# STROUD ENGINEERING, P. A.

June 24, 2024  
Mr. Matt Conte  
Eleven 18 Architecture  
1011 E. Colonial Drive, Suite 307  
Orlando, Florida 32803

RE: Springs of Ballentine

PLUMBING ROUGH-IN
SCALE: 1/4"=1'-0"

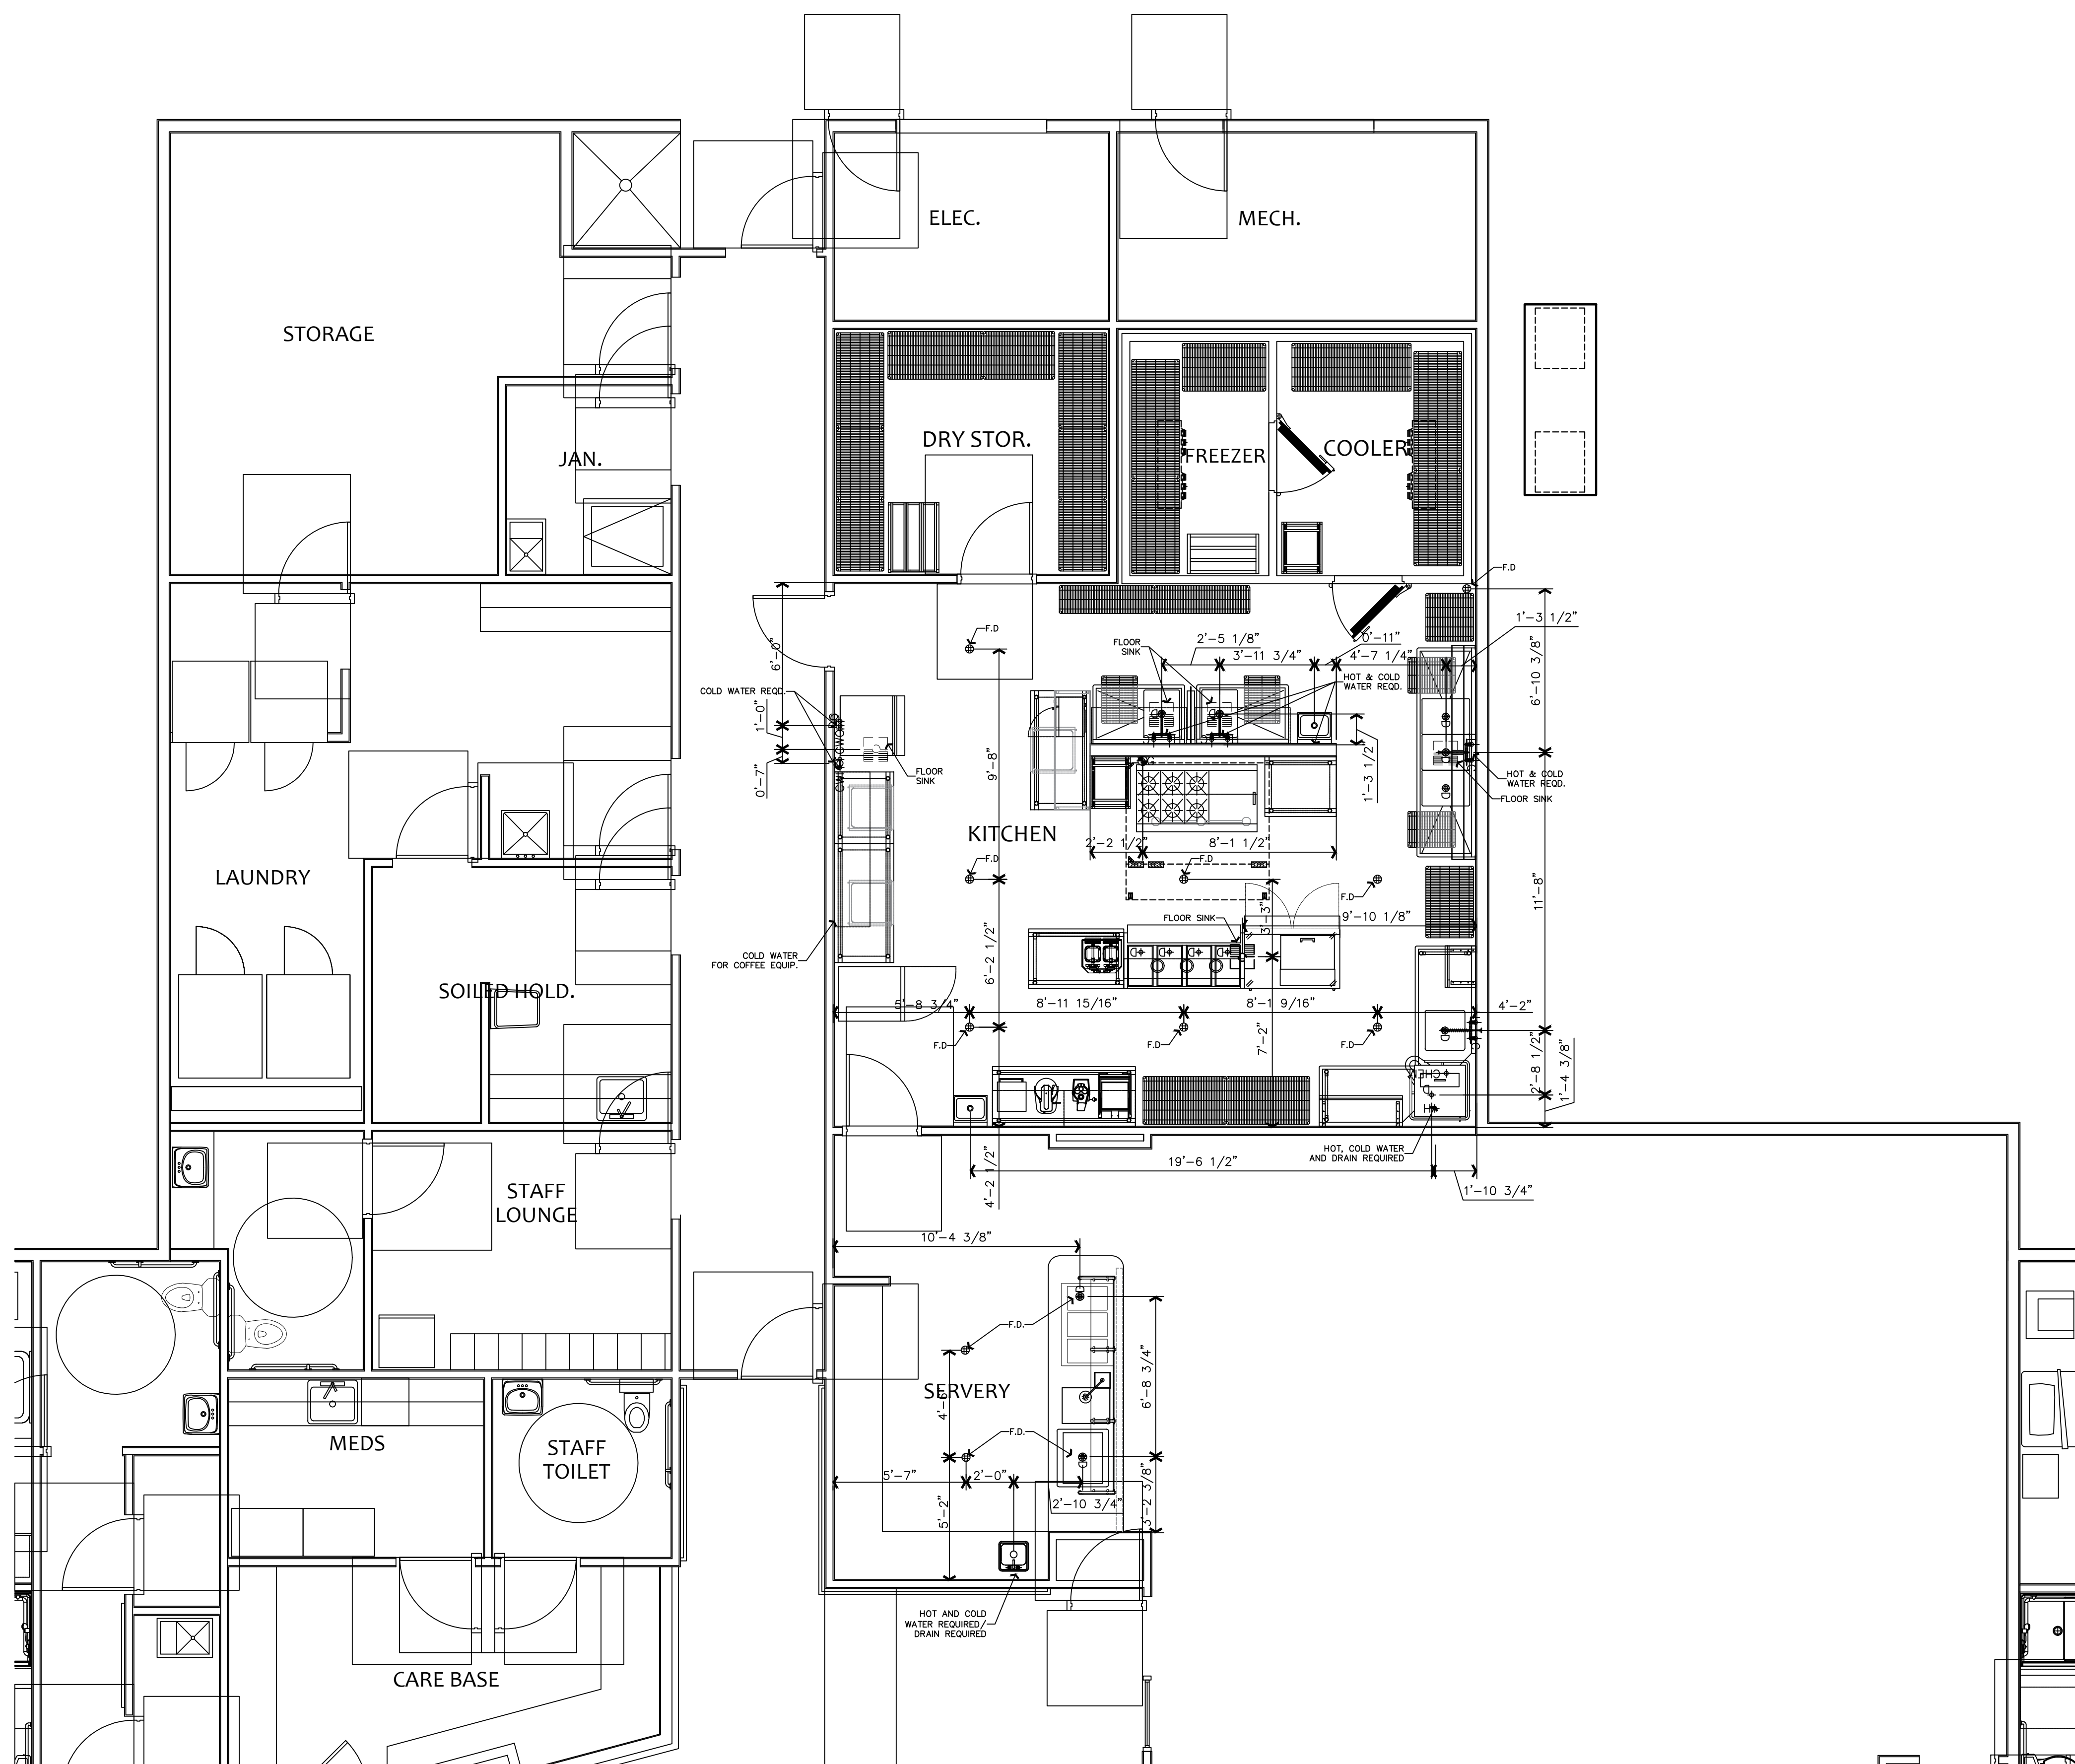
This letter is to approve use of a Schier model number GB-250 grease interceptor in place of the unit shown on the plans contingent approval of all authorities having jurisdiction. Owner shall also be made aware that this unit will need to be pumped out more frequently given that it is a lower capacity unit.
